KIRKLEES METROPOLITAN COUNCIL INVESTMENT & REGENERATION SERVICE

DELEGATED DECISION TO DETERMINE PLANNING APPLICATIONS

Reference No:	2026/62/91139/E
Site Address:	1, Charnwood Bank, White Lee, Batley, WF17 8PY
Description:	Erection of side and rear extensions, formation of driveway with dropped kerb to front elevation and associated works
Recommending Officer:	Elenya Jackson

DECISION – REFUSED

Proposed Plans/Elevations

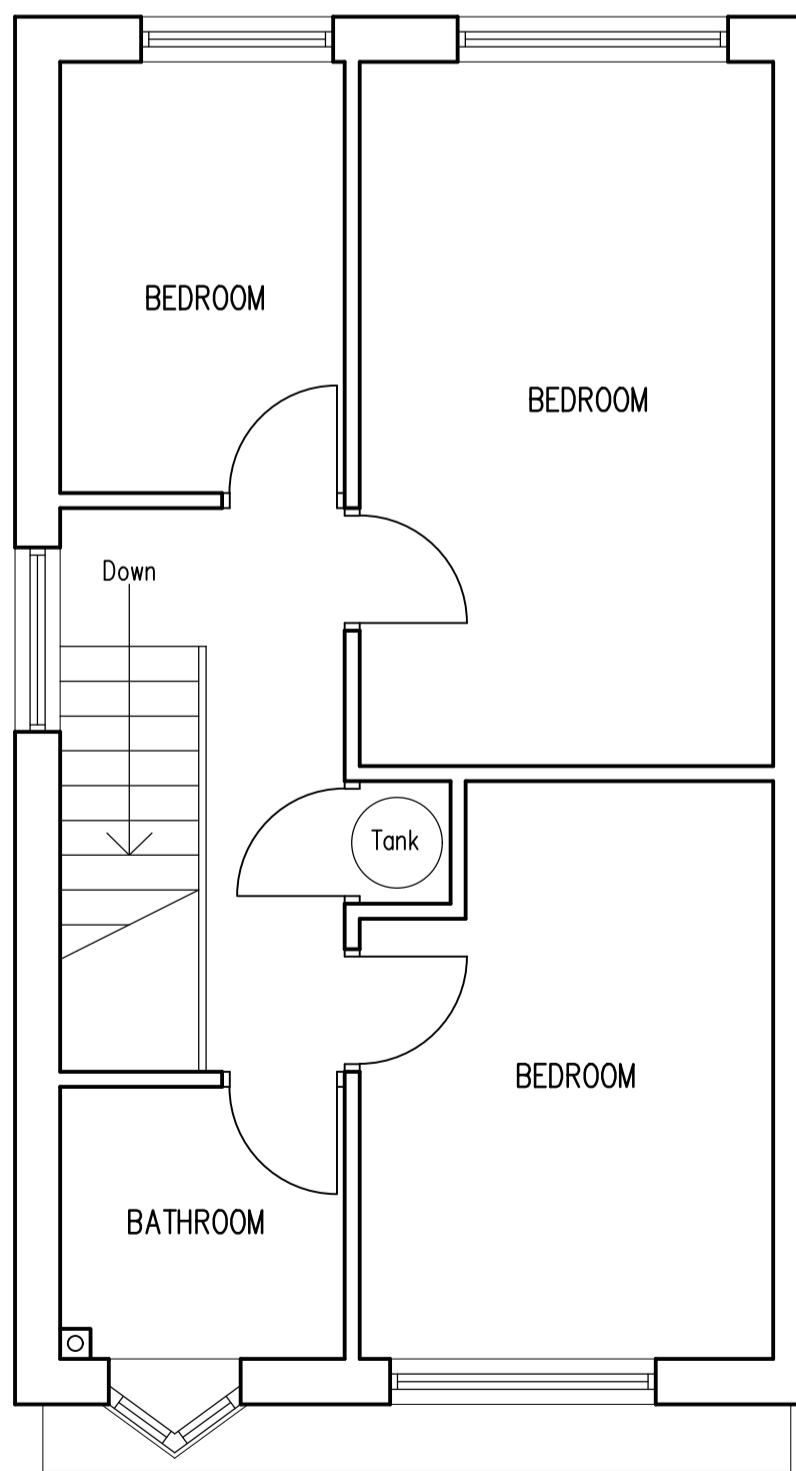
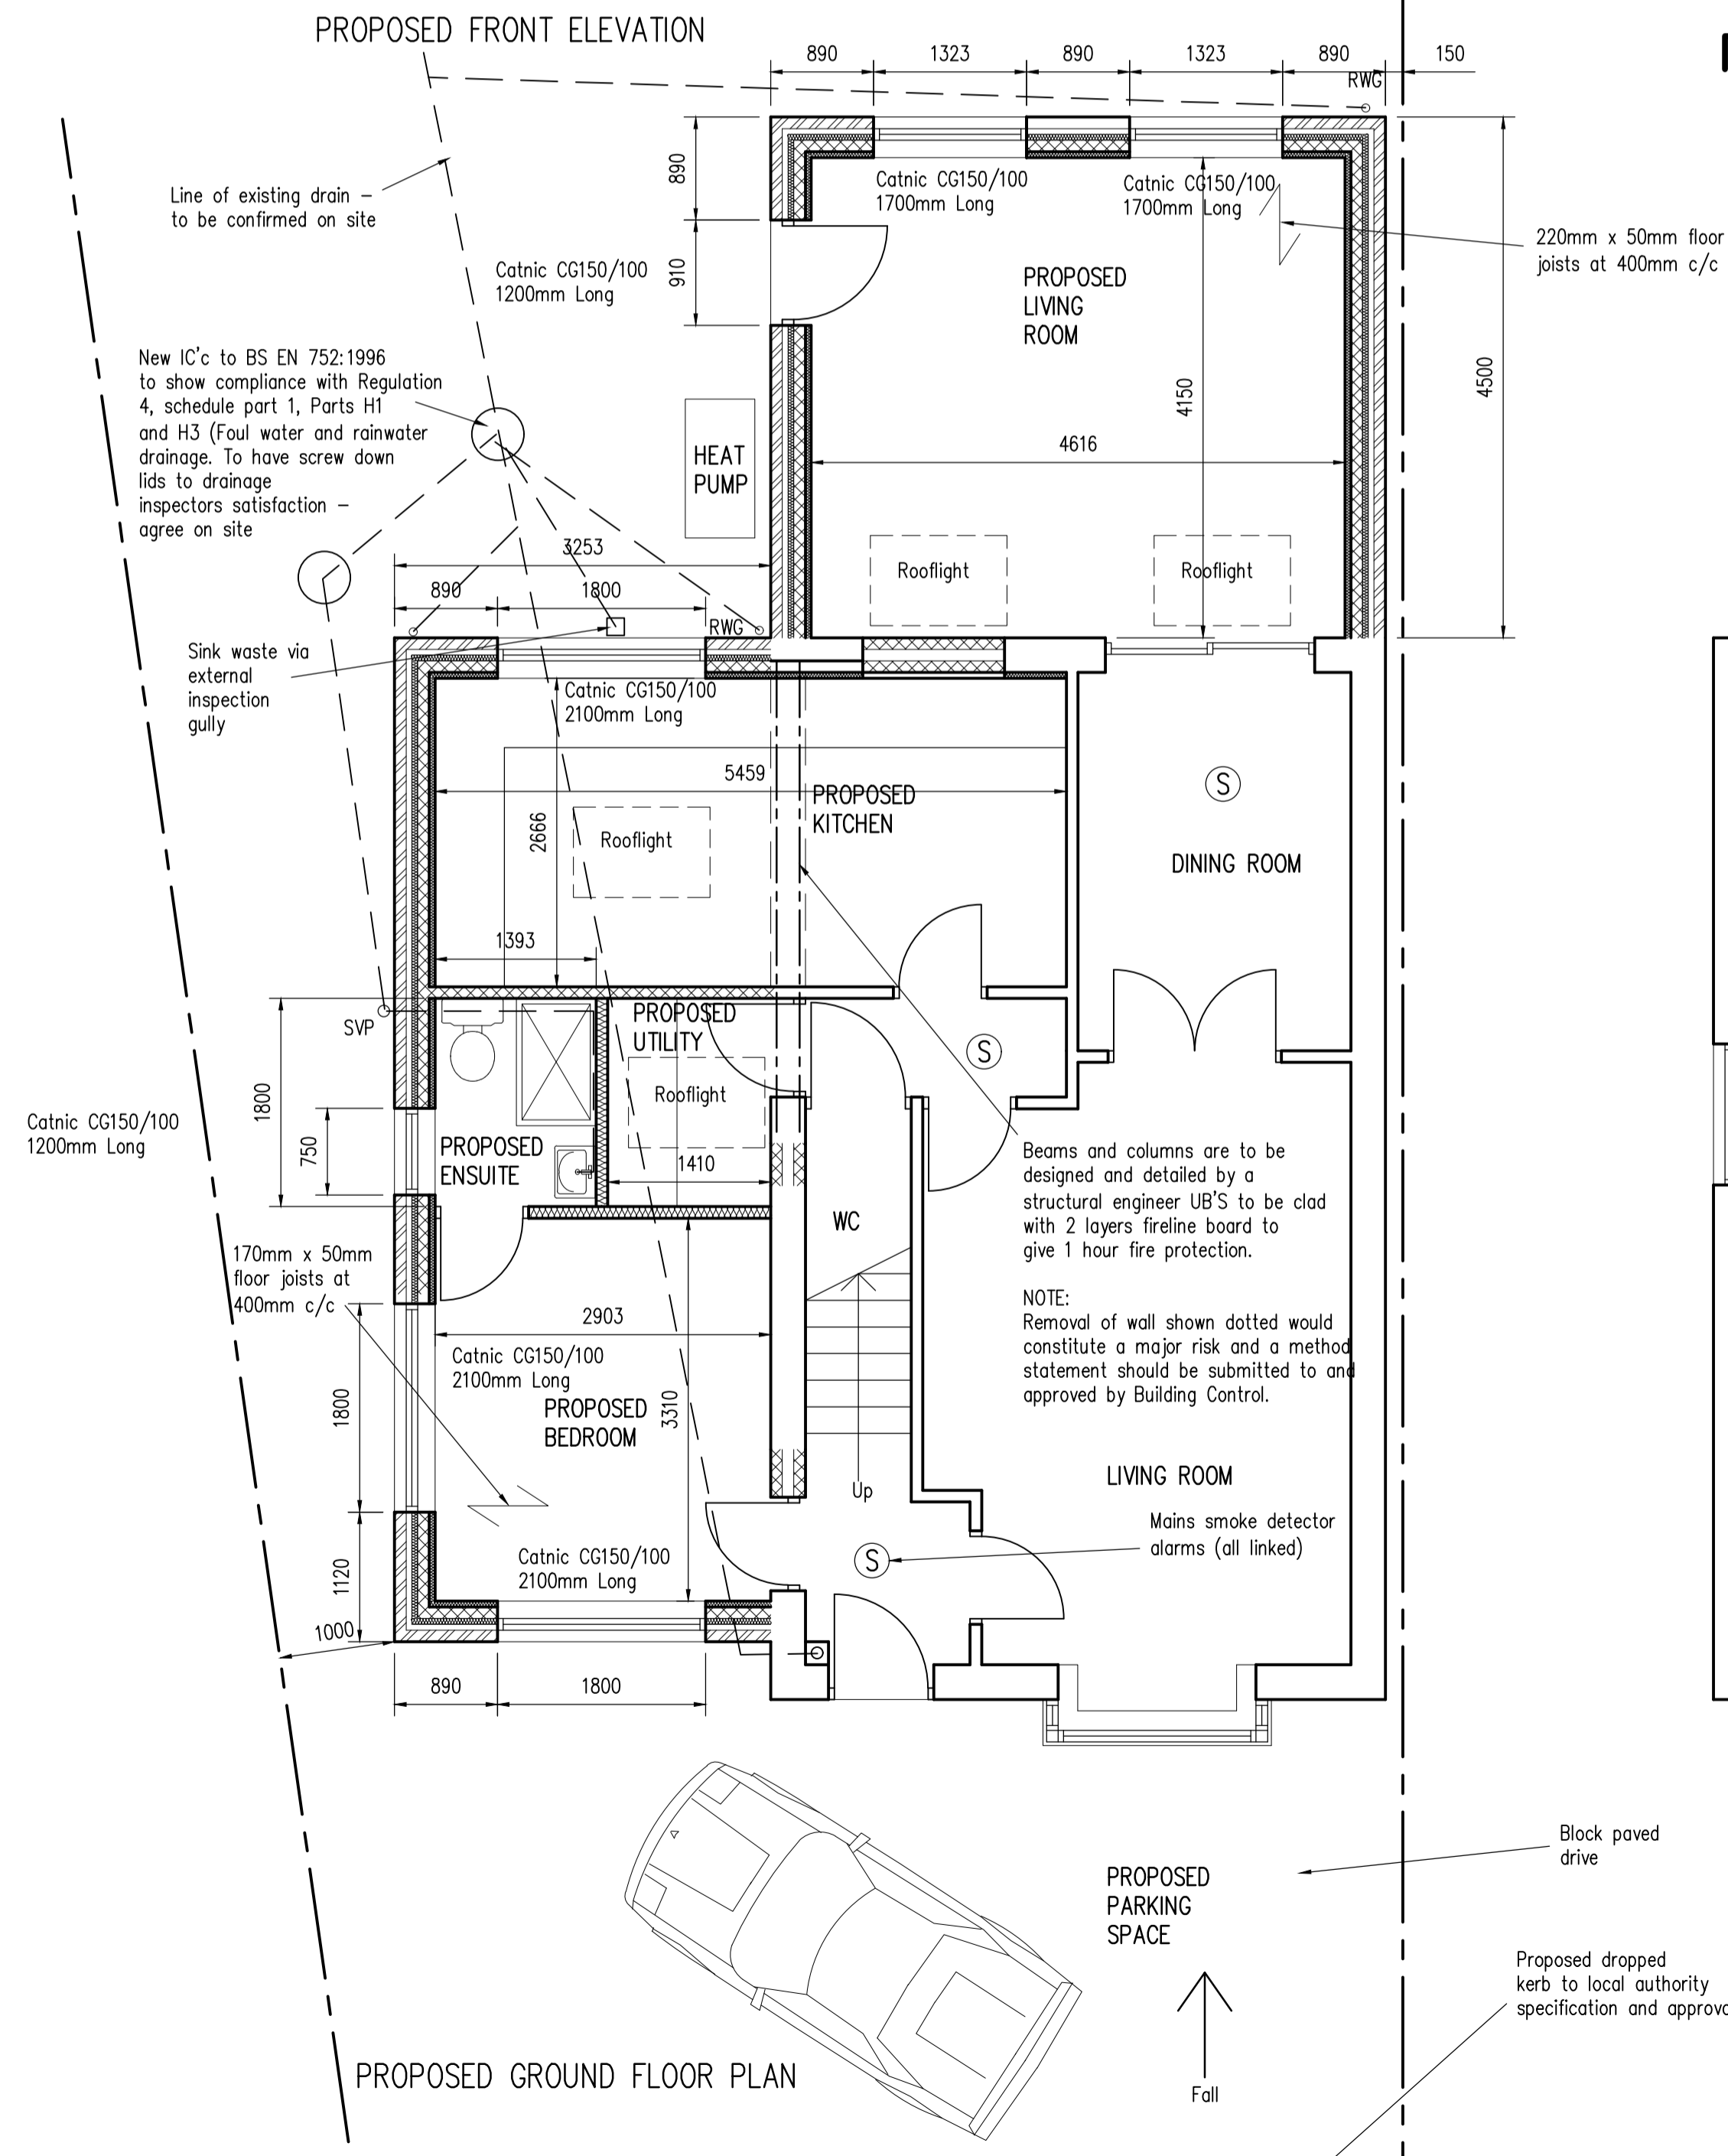
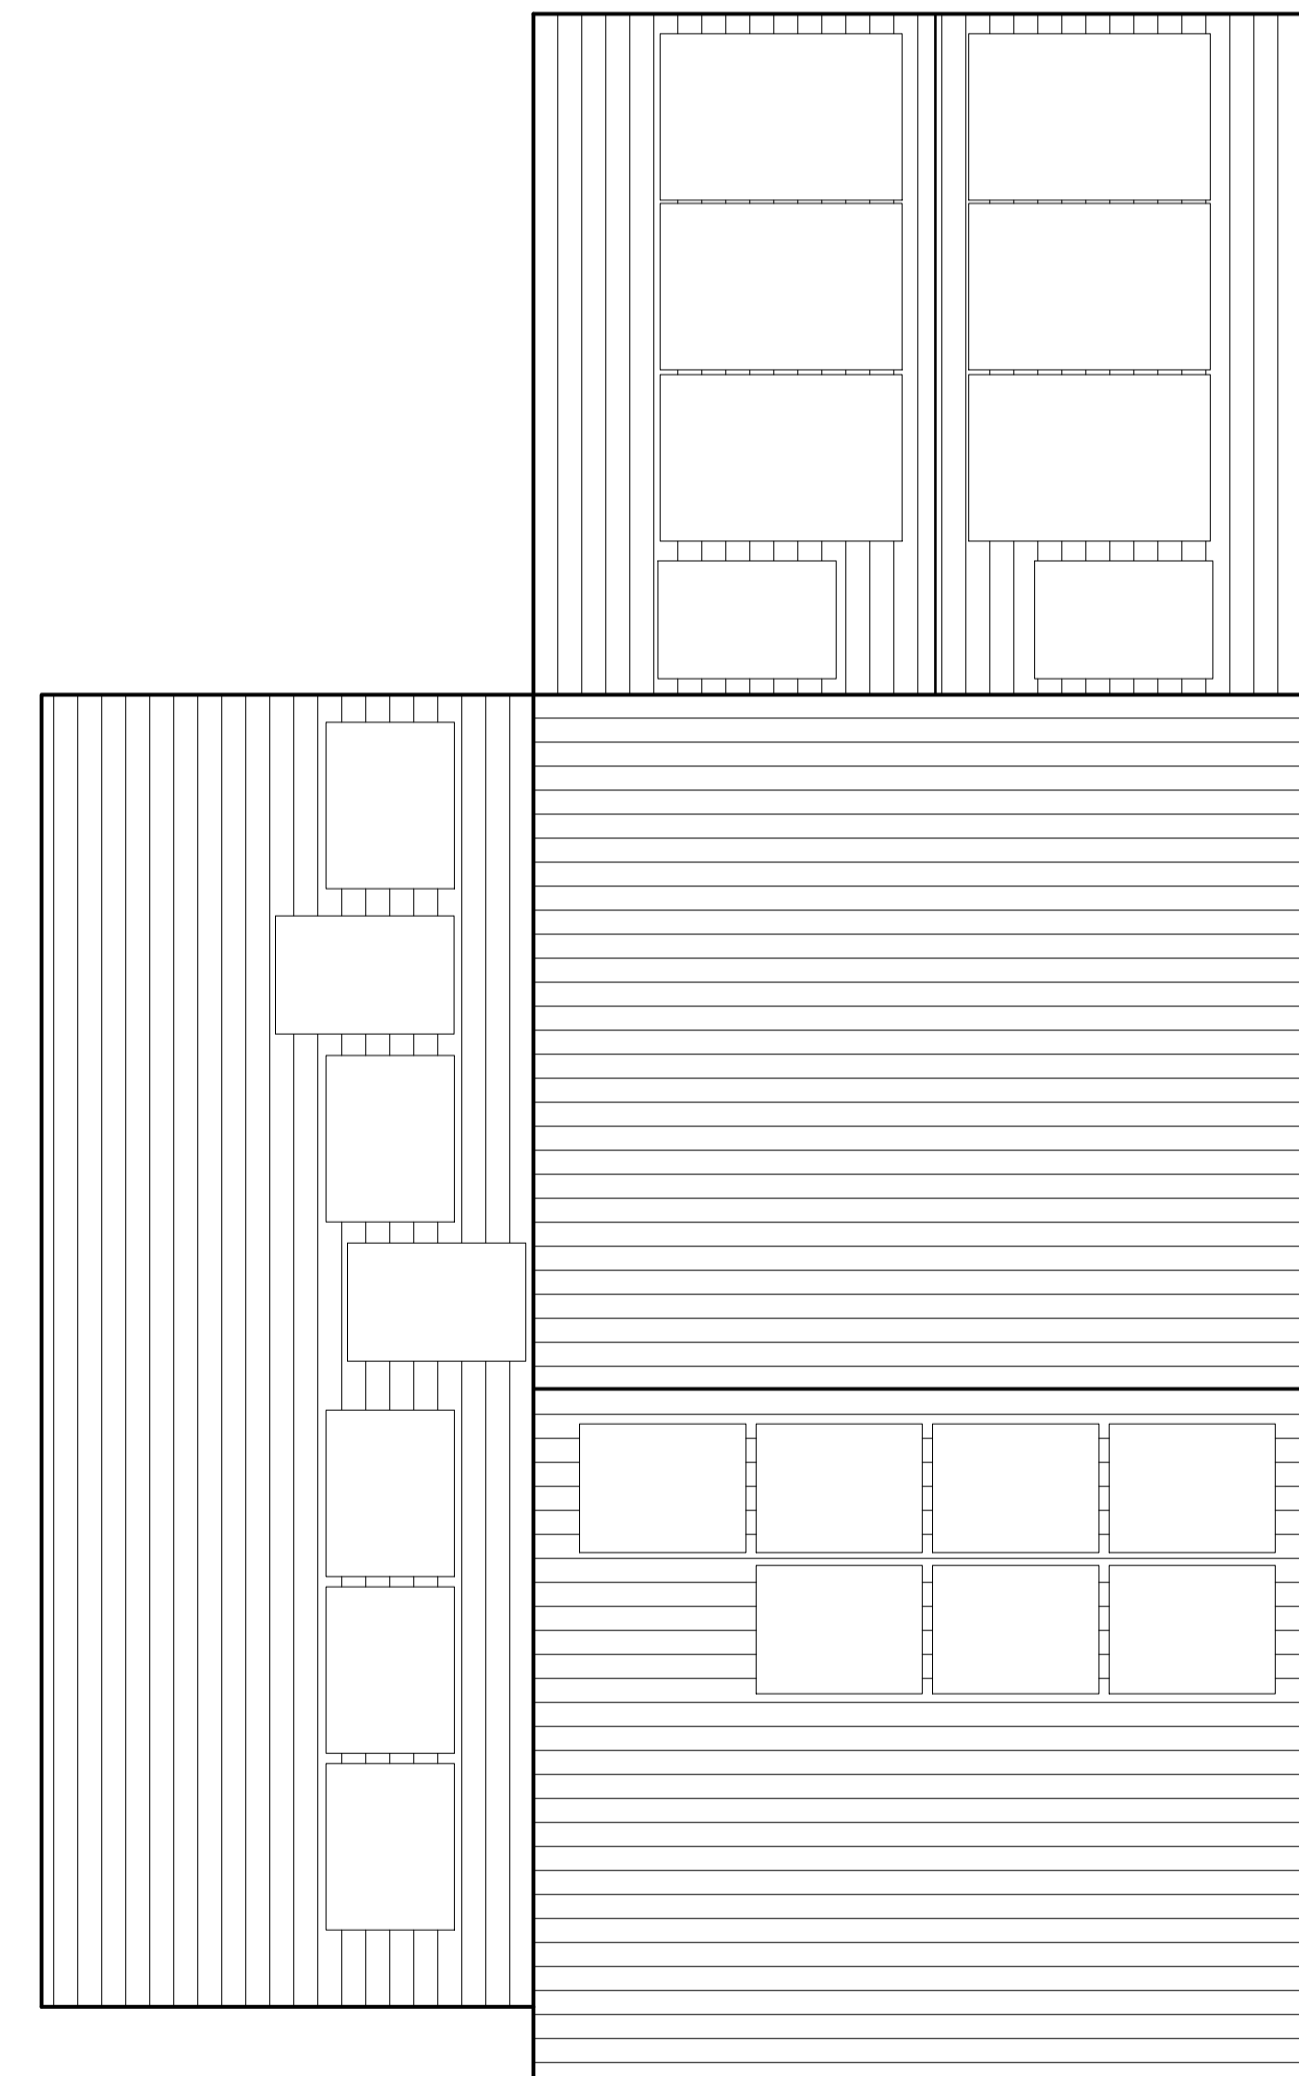
The submitted plans include an annotation 'Heat Pump' which is adjacent to the proposed extensions. This is not included within the description of development in the submitted application form and no details of this have been provided. Notwithstanding the fact this element of the scheme is not included in the assessment of the development it is noted there remains potential for undertaking a heat pump by utilising permitted development rights.

Officers acknowledge that the proposed rear extension would project 0.5m beyond the recommended parameters of the House Extensions and Alterations SPD. However, it is considered that there is an existing single storey rear projection on site which the proposal would not extend substantially beyond.

It is considered that on the basis of inclusion of conditions requiring use of matching materials, the single storey extension to rear could be considered acceptable in this case given there is a marginal exceedance of the recommendations of the SPD and in this case it would not lead to a significant increase in harm in relation to visual amenities.

In this case, whilst the proposal has been amended with a reduction to the size and scale of the extension to side, it would be in close proximity to the street and would see a development which has a cramped appearance. The single storey side extension is such that by virtue of its siting, design, scale and projection beyond the established building line, it would result in a cramped form of development which would fail to appear subservient to the host dwelling and appear unduly prominent and incongruous within the street scene, to the detriment of visual amenity. The single storey side extension would therefore be contrary to Policy LP24 of the Kirklees Local Plan, Key Design Principles 1 and 2 of the House Extensions and Alterations SPD, and Chapter 12 of the National Planning Policy Framework.
